# CITY OF ALBUQUERQUE

**Re:** A-Tech Security  
**4616 Hawkins NE**  
**Traffic Circulation Layout**  
Engineer's Stamp dated 07-07-16 (D17D104)

**Re: A-Tech Security  
4616 Hawkins St., NE  
Traffic Circulation Layout  
Engineer's/Architect's Stamp dated 5-25-16 (D17-D104)**

**Re: Nelson-Hawkins Lot #16-A(1)**  
**4616 Hawkins St., NE**  
**Traffic Circulation Layout**  
Engineer's/Architect's Stamp dated 11-16-15 (D17-D104)

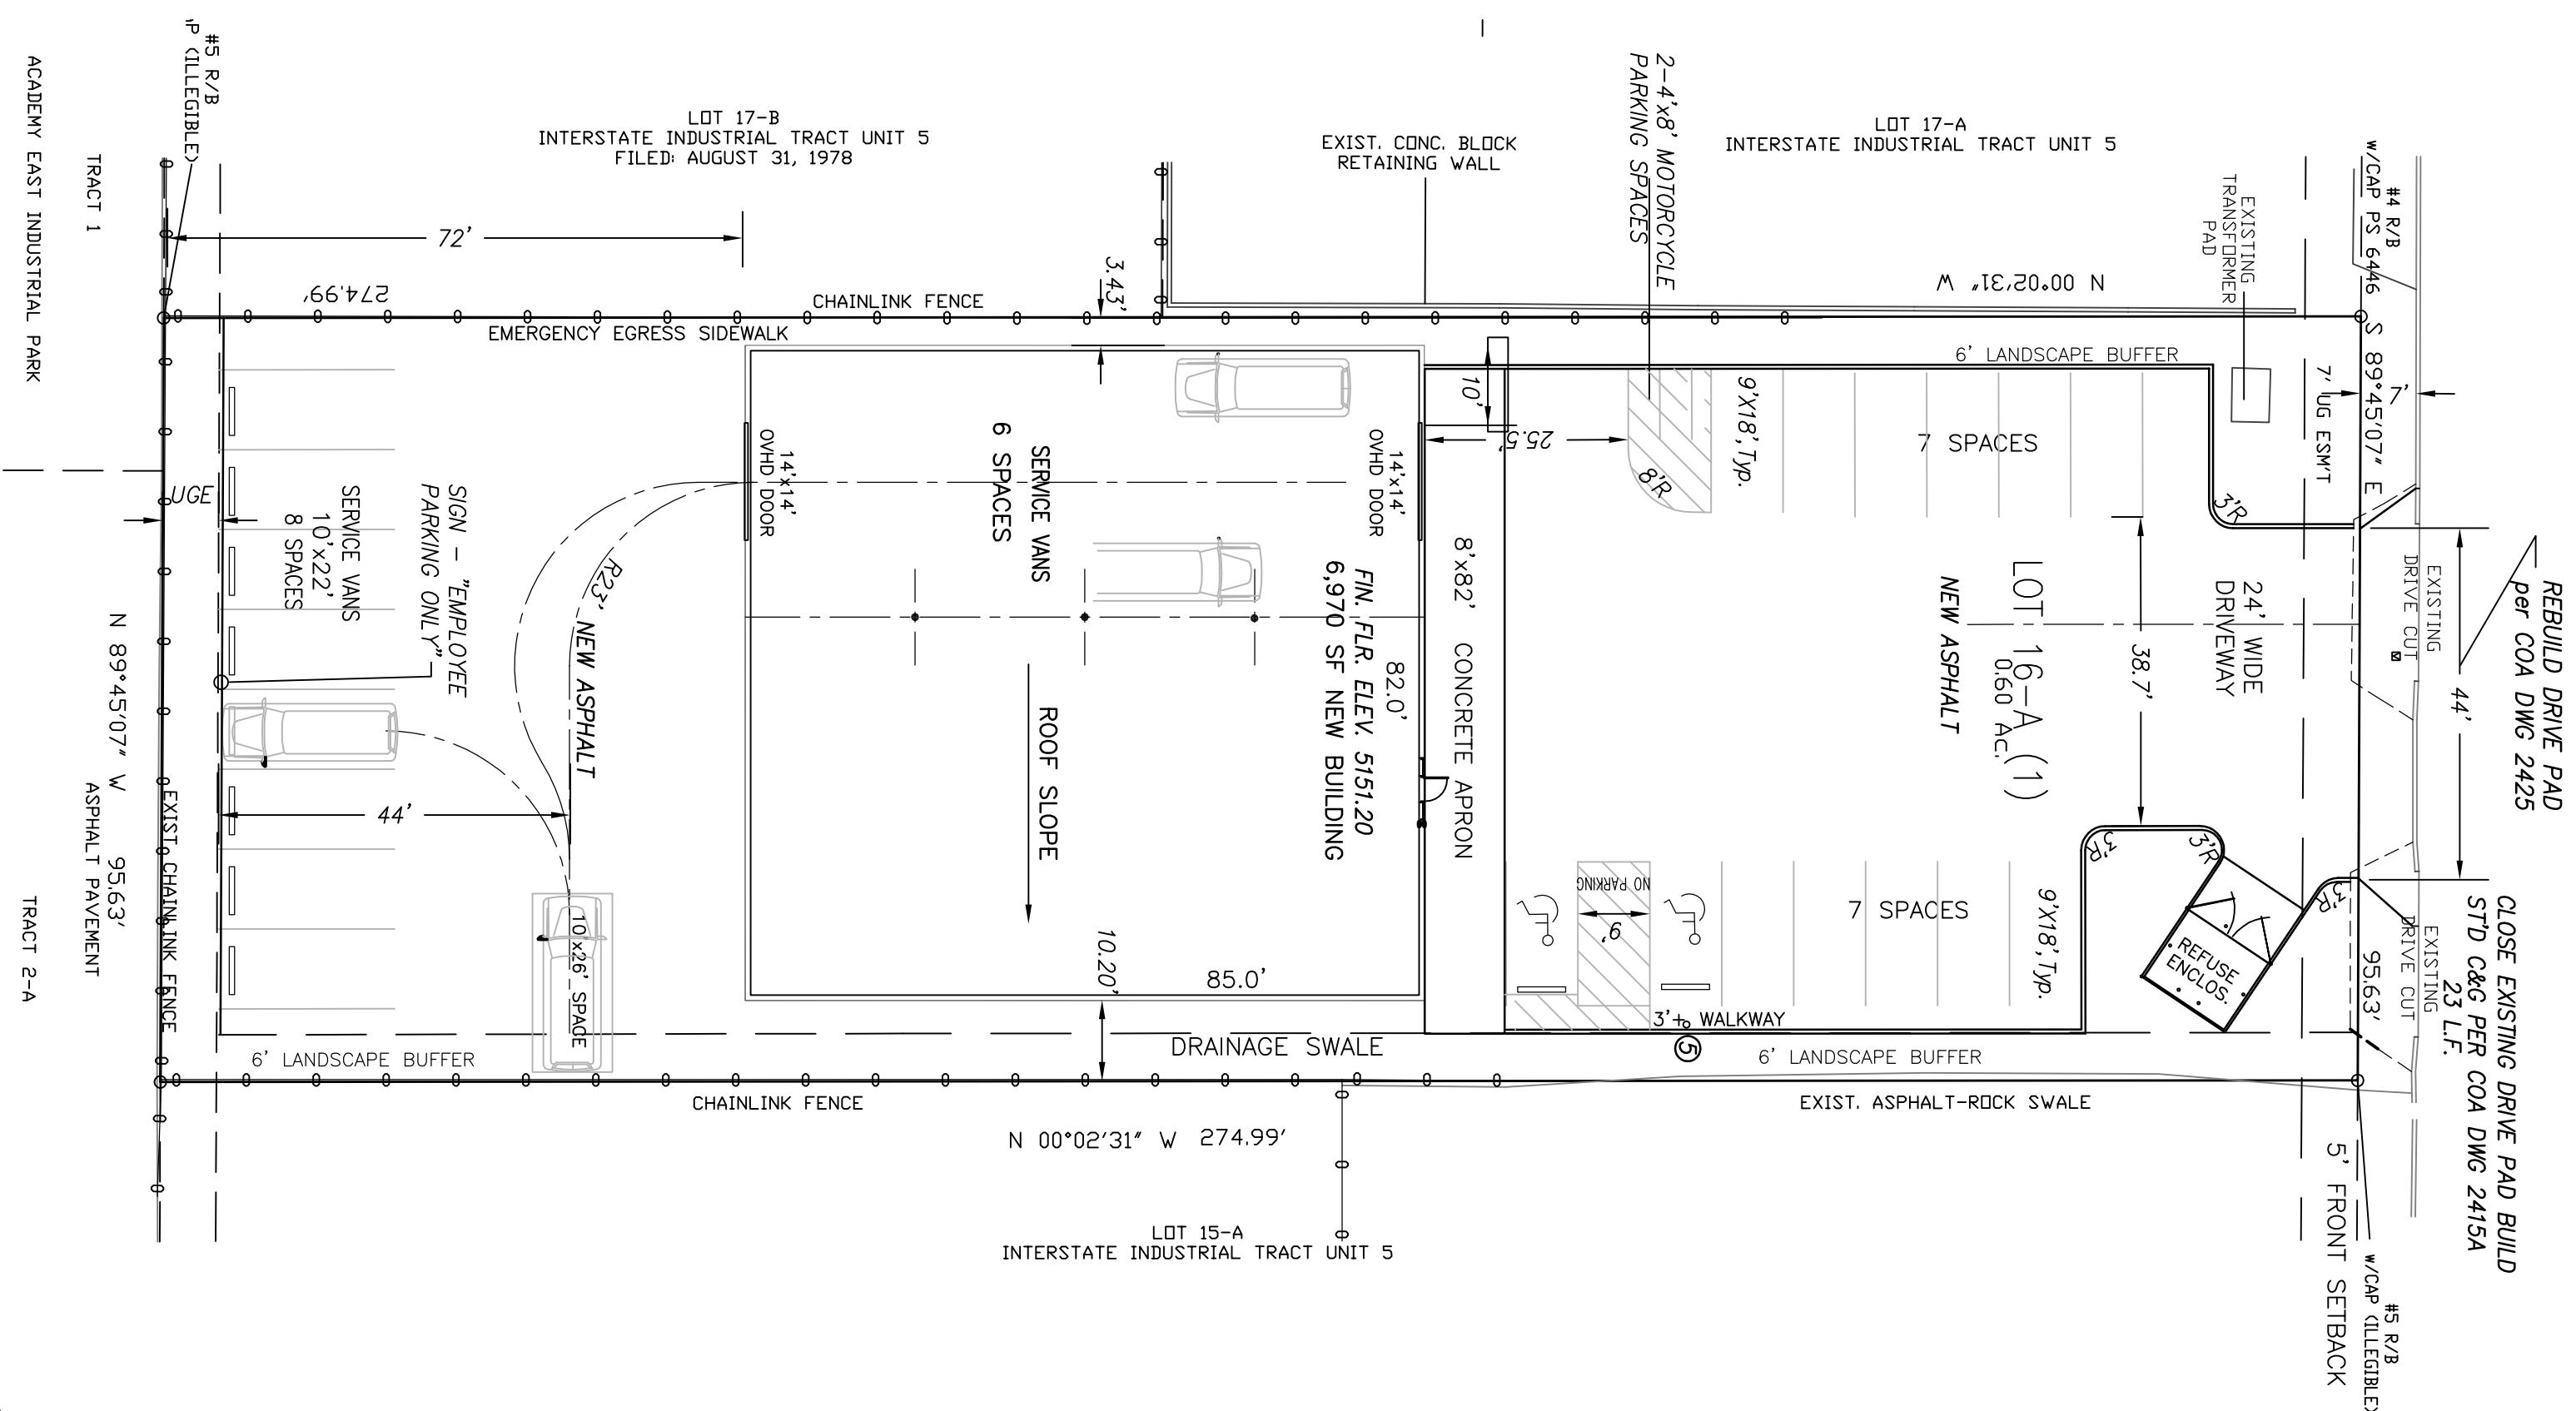
The TCL submittal received 08-05-16 is approved for Building Permit. A copy of the stamped and signed plan will be needed for each of the building permit plans. Please keep the original to be used for certification of the site for final C.O. for Transportation.

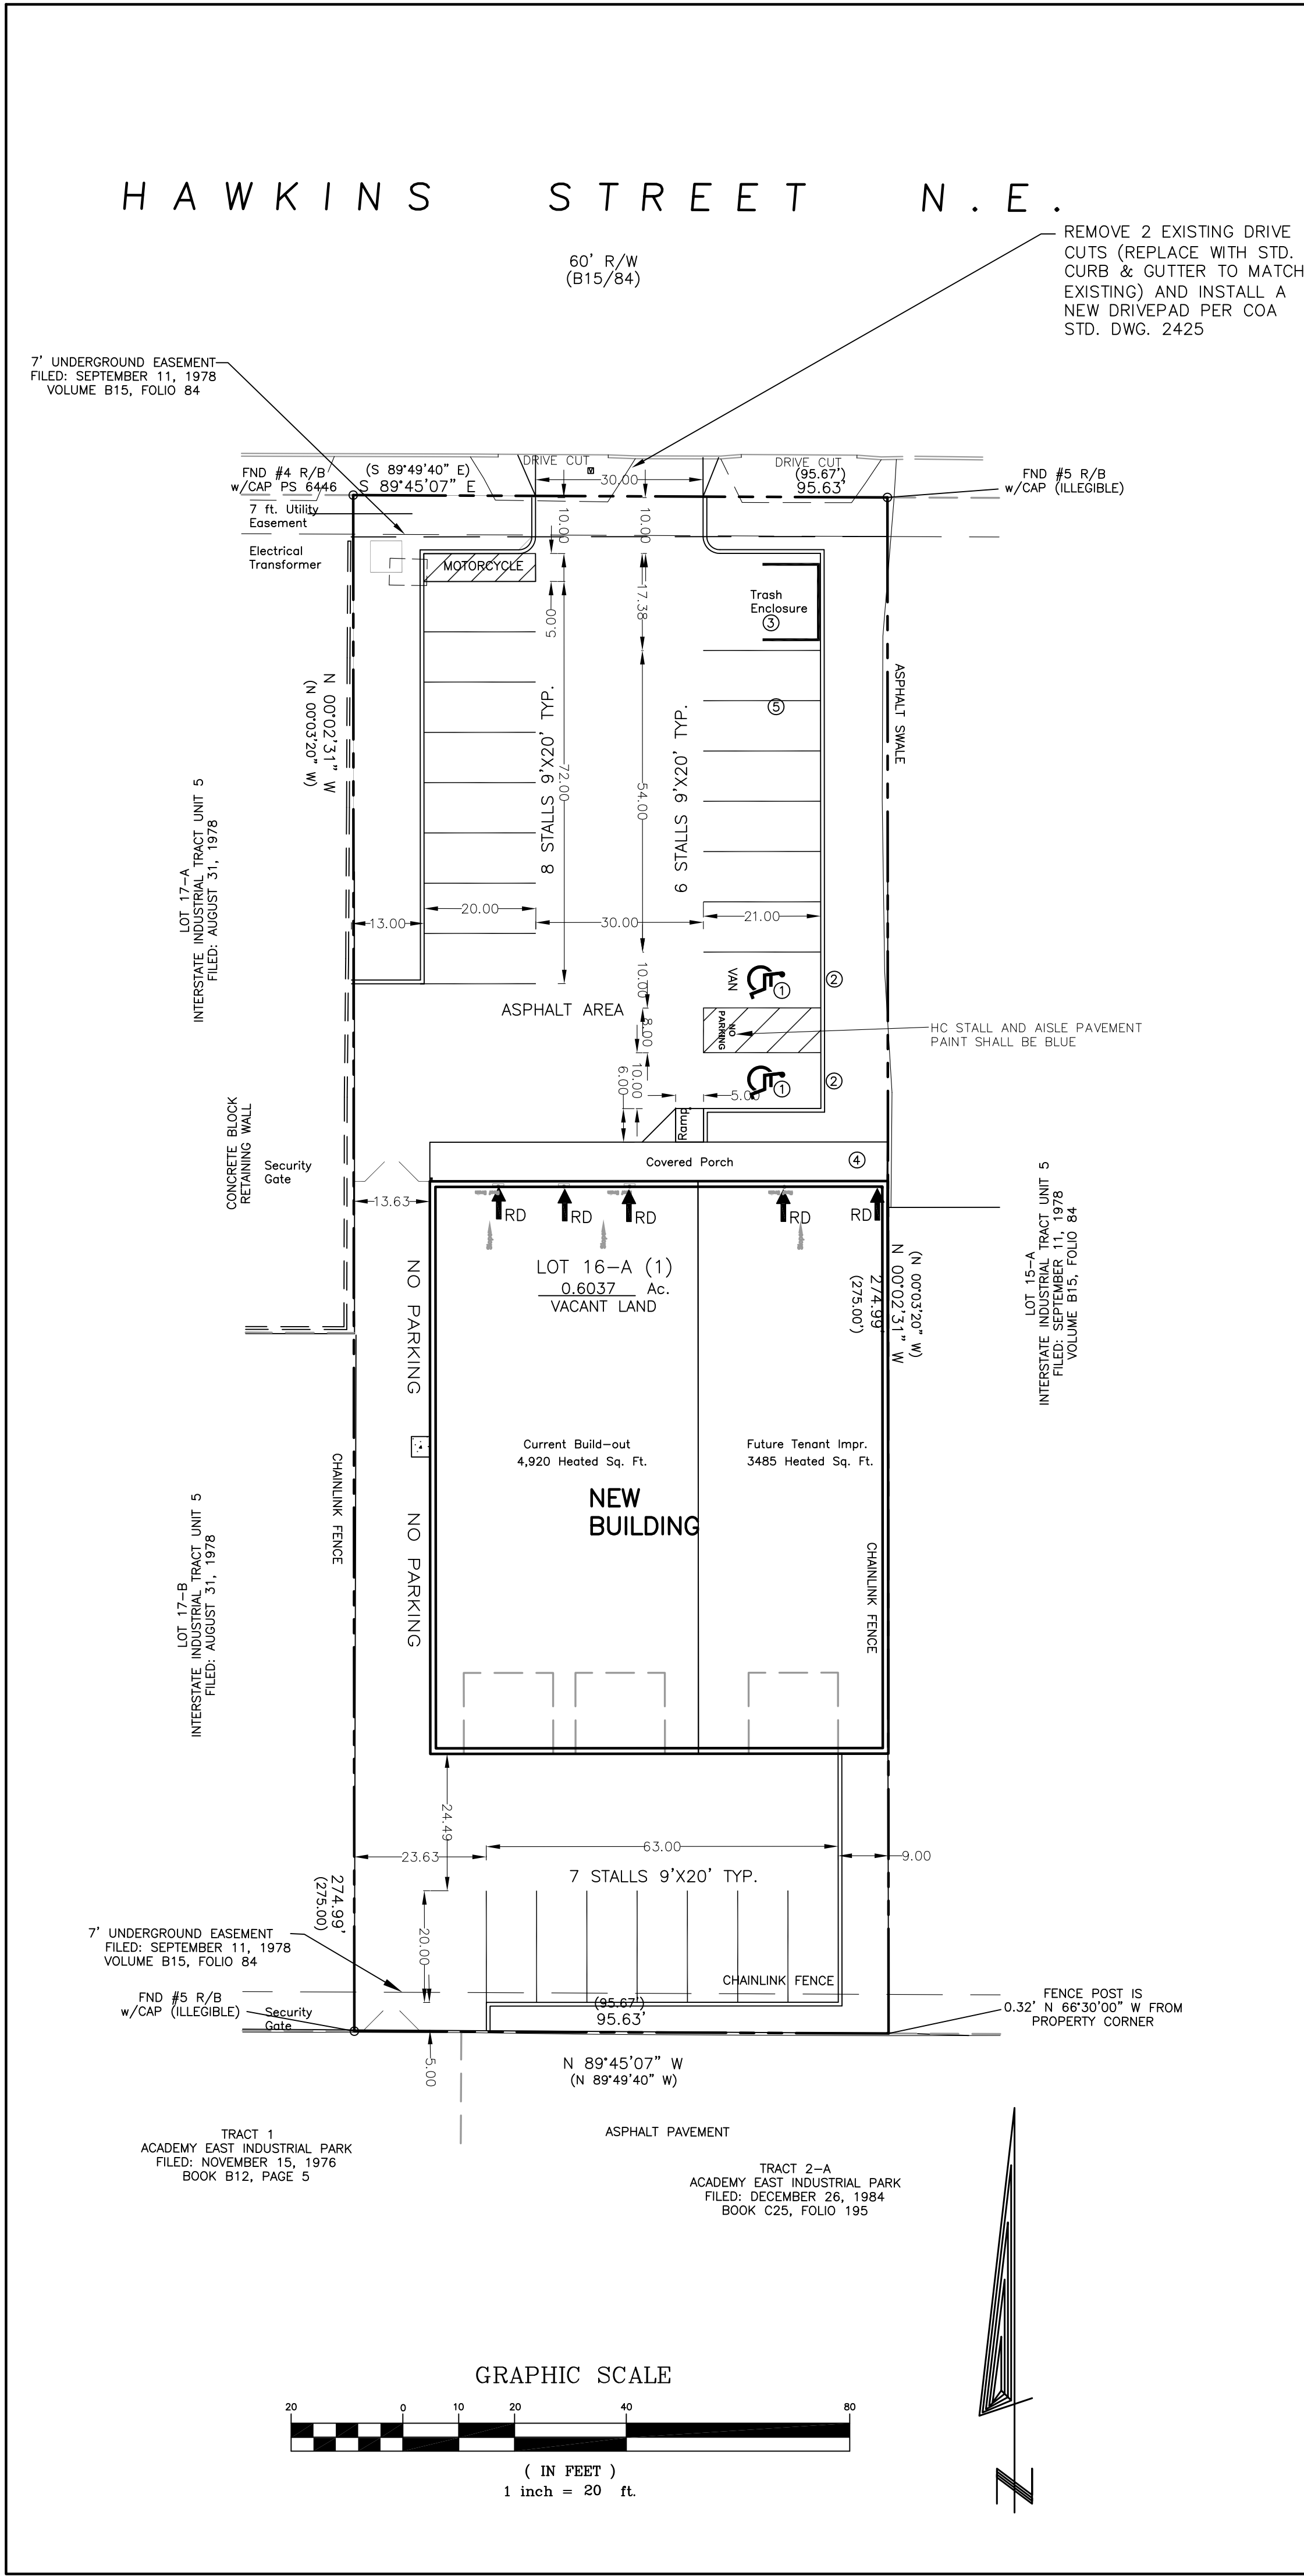
1. Please identify all existing buildings, doors, structures, sidewalks, walls and anything that influences the parking and circulation on the site. Please include the dimensions of the covered porch.

2. Show all curb radii.
3. The drive pad width for two-way traffic to the parking spaces located at the south end of the building must be 24 ft. min.
4. A 5 ft. keyway is required for dead-end parking aisles.

5. Please state the type of material to be used for the parking lot on the south end of the project site.
6. Per the DPM, a 6 ft. wide ADA accessible pedestrian pathway is required from the public sidewalk to the building entrances. Please clearly show this pathway and provide details from Hawkins St. Provide detail of ADA ramp from public R.O.W.

7. Per the DPM, a 6 ft. wide ADA accessible pedestrian pathway is required from the HC parking stall access aisles to the building entrances. Please clearly show this pathway to the building entrance.

8. Provide a min 6" or max 8" high concrete barrier curb or other acceptable barrier between landscaping and parking areas and/or drive aisles.
9. Design delivery vehicle route needs to be shown.

10. Service vehicle and/or refuse vehicle maneuvering must be contained on-site; provide a copy of refuse approval.

11. Please provide a sight distance exhibit (see the *Development Process Manual, Chapter 23, Section 3, Part D.5 Intersection Sight Distance*). Please show this detail for the entrance/exit on Hawkins St.

12. Please add the following note to the clear sight triangle: "Landscaping and signage will not interfere with clear sight requirements. Therefore, signs, walls, trees, and shrubbery between 3 and 8 feet tall (as measured from the gutter pan) will not be acceptable in this area."
13. Unused curb cuts must be replaced with sidewalk and curb & gutter. A build note must be provided referring to the appropriate City Standard drawing.
14. Please include two copies of the traffic circulation layout at the next submittal.
